# TECHNICAL NOTE

from:	ALAN DAVIES	date:	7/12/2020
subject:	<b>PROPOSED RESIDENTIAL DEVELOPMENT HIGH MOOR CLITHEROE</b>	file ref:	J1002-TN1

This Technical Note sets out the response to the highway feedback.

Figure: 14  
 Title: Proposed Residential Development Distribution - Based on Approved Standen Development

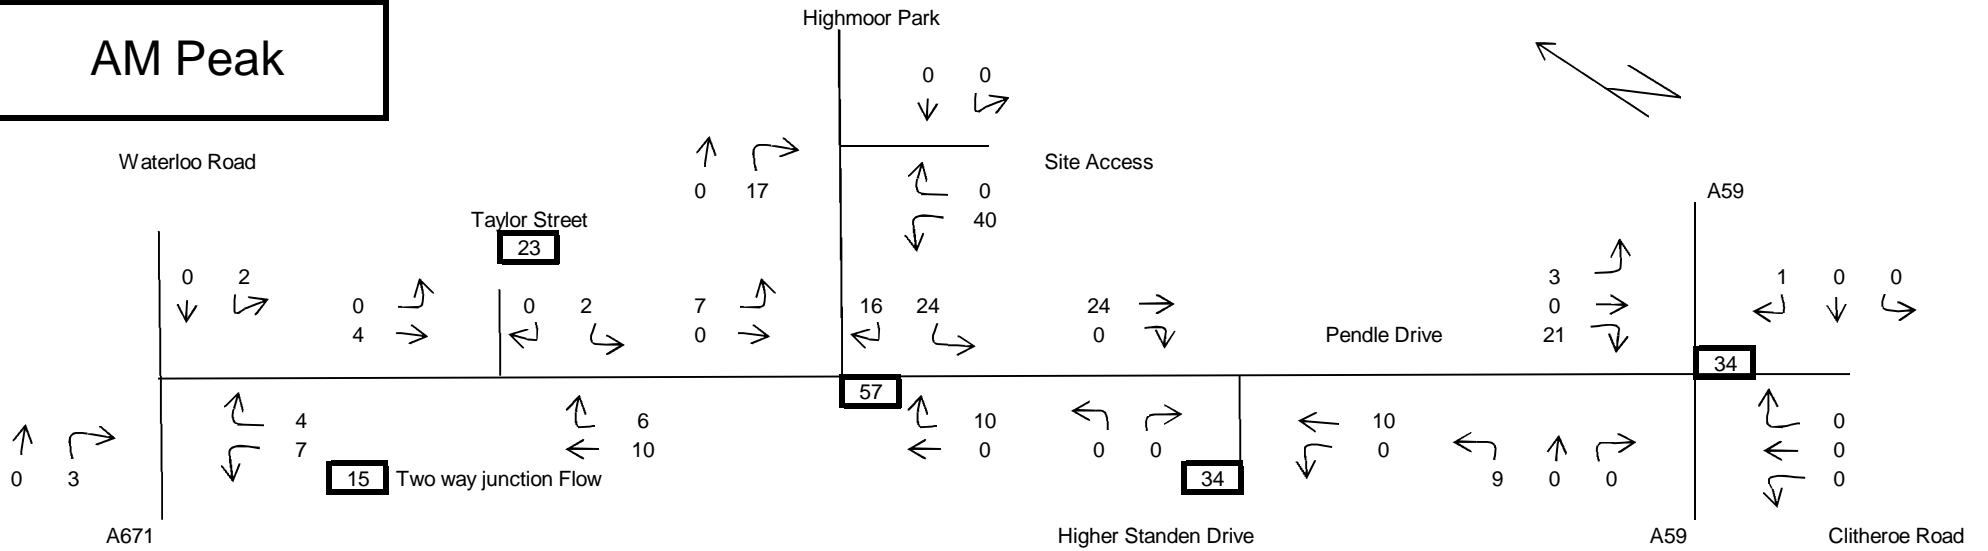
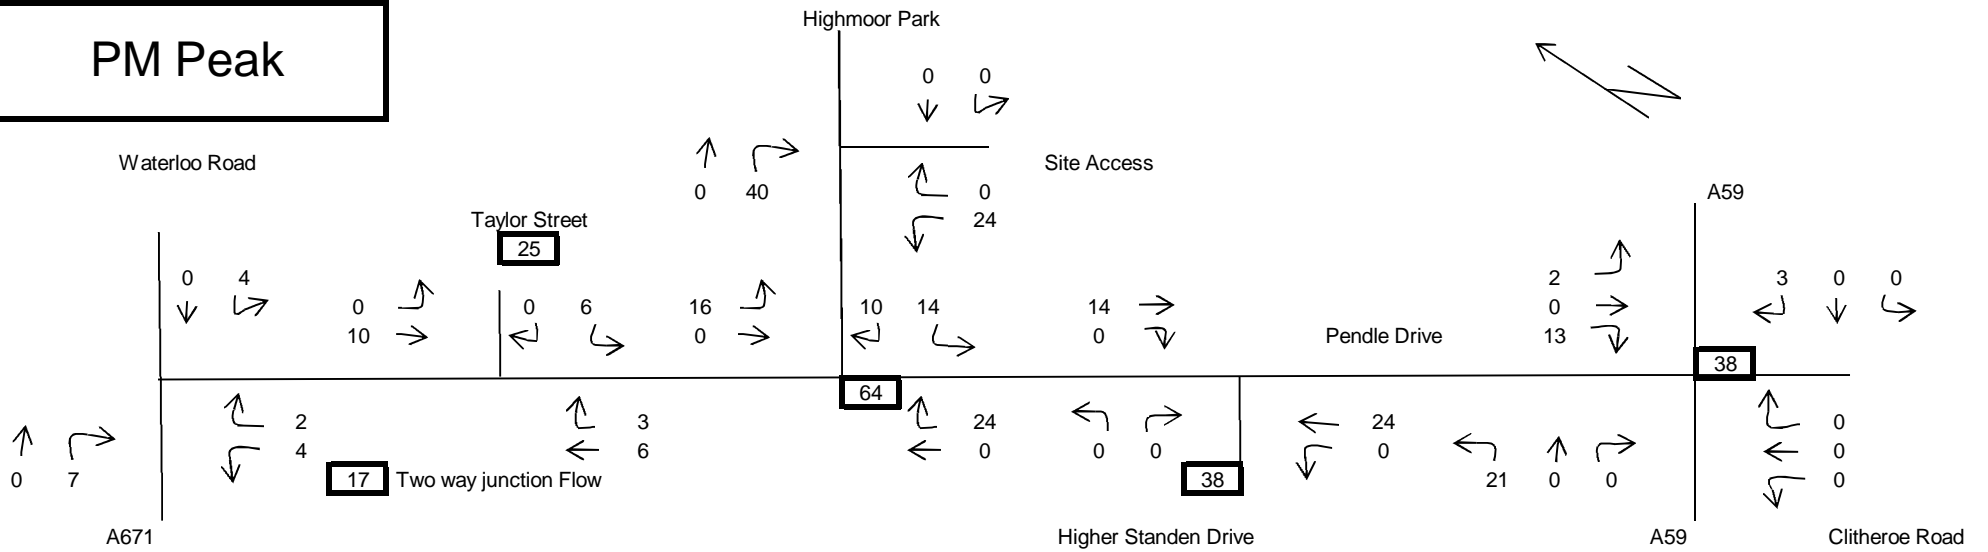
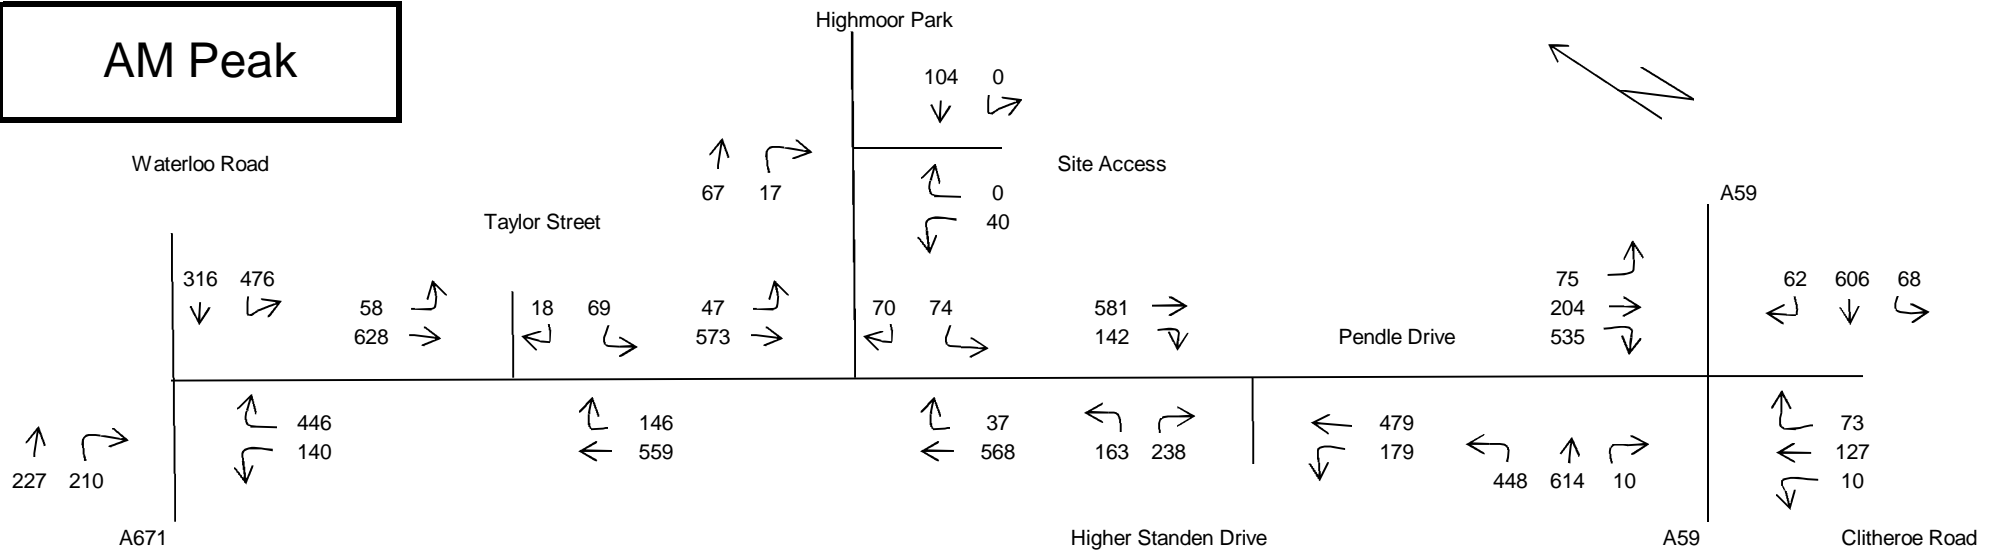
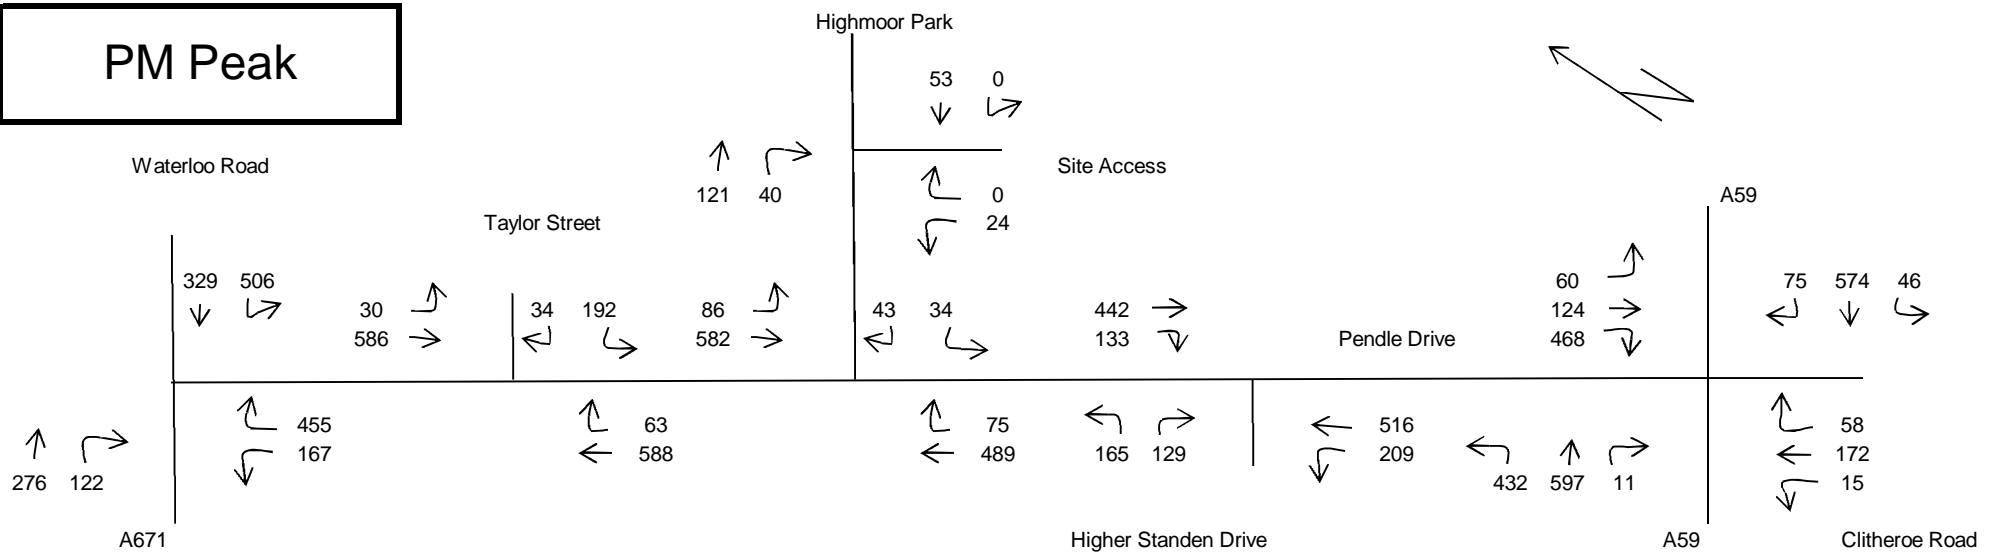
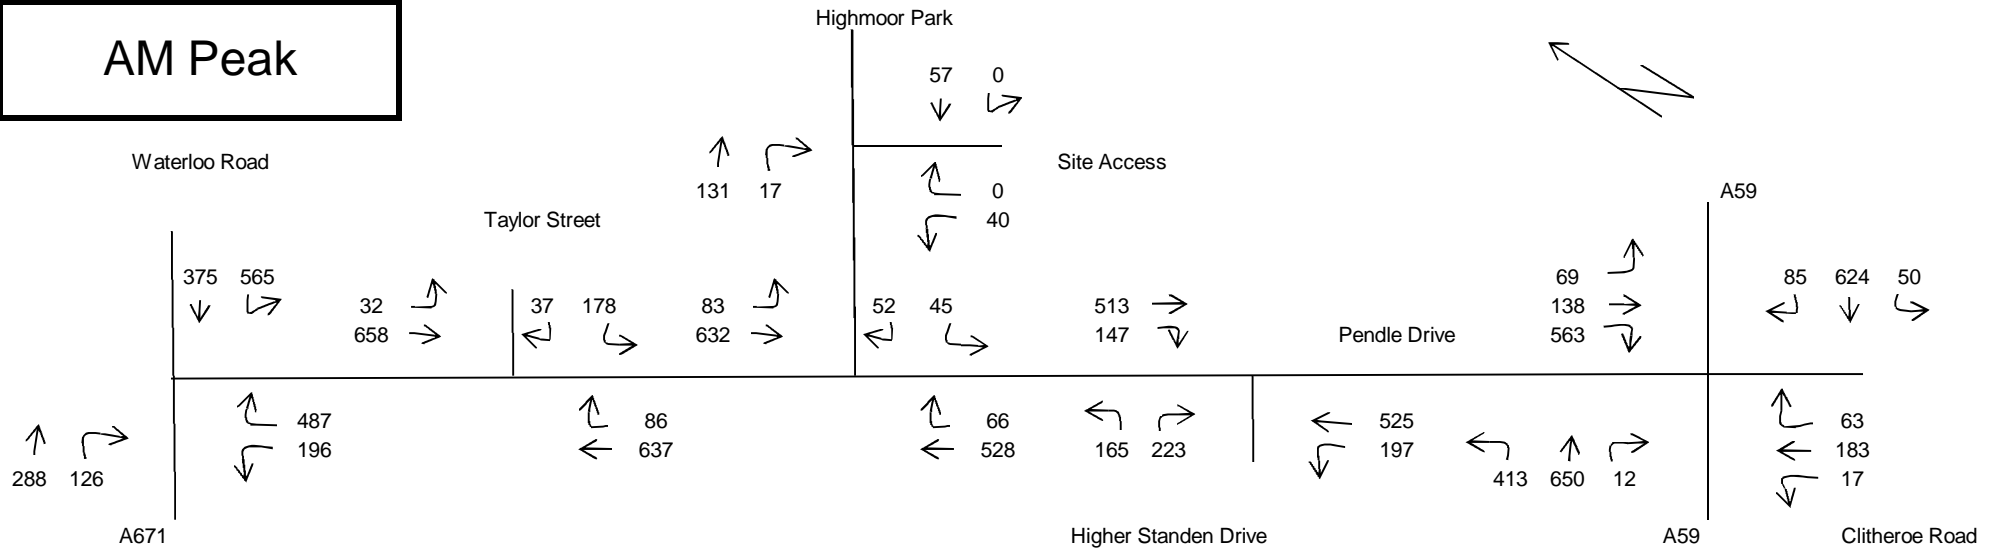
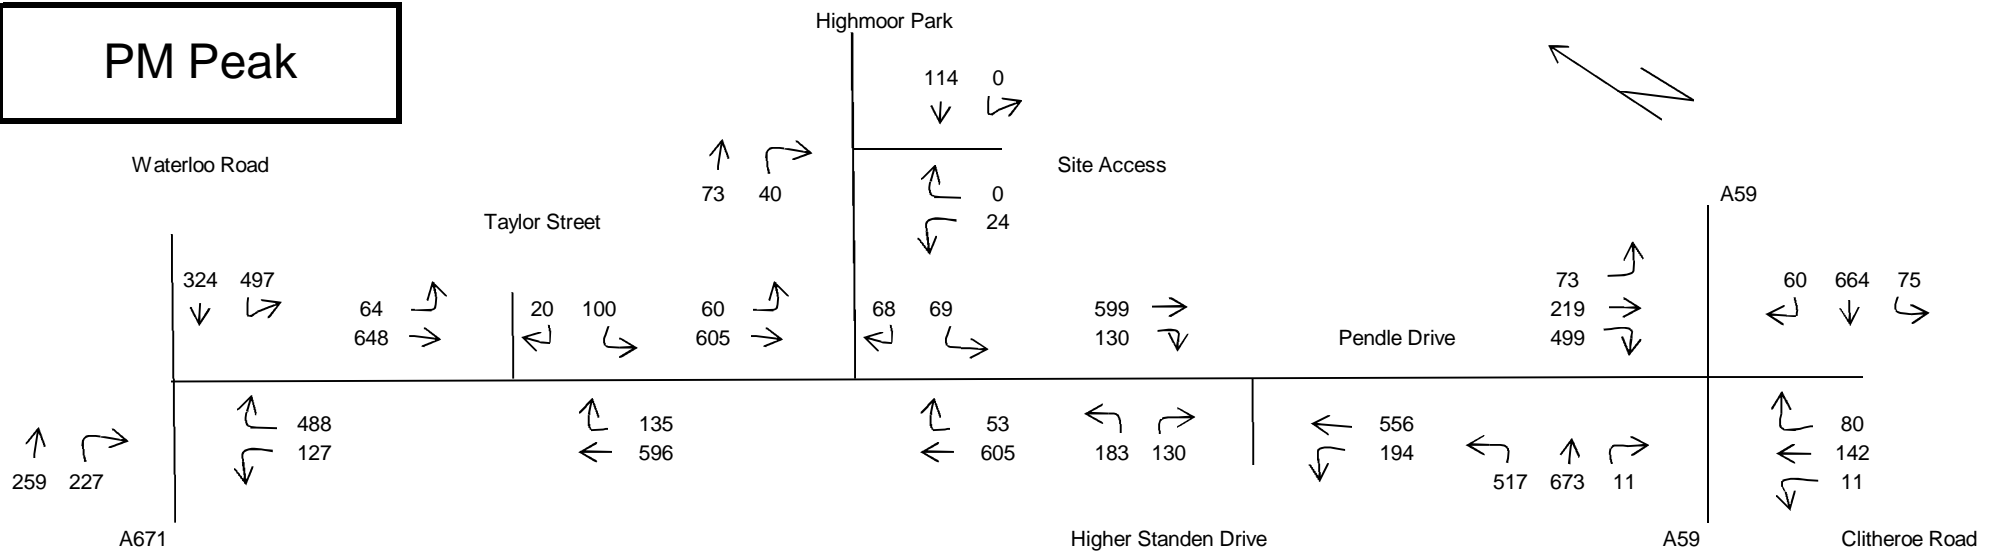
*The confirmation from the Standen Development is sufficient to justify the use of the trip rates quoted.*

*LCC further requested using these figures can you assess the impact on the Waterloo Road / Shaw bridge Street junction.*

**Appendix B provides the feedback on this item as agreed.**

**The issue is that the committed development have agreed monies to be paid to improve this junction to support that developments however to date no approved scheme has been adopted.**

**Given this it has been agree with the Highway Authority to use the fallback improvement scheme at the junction for lane widening which will be tested with the proposed development flow in 2020 and 2030.**
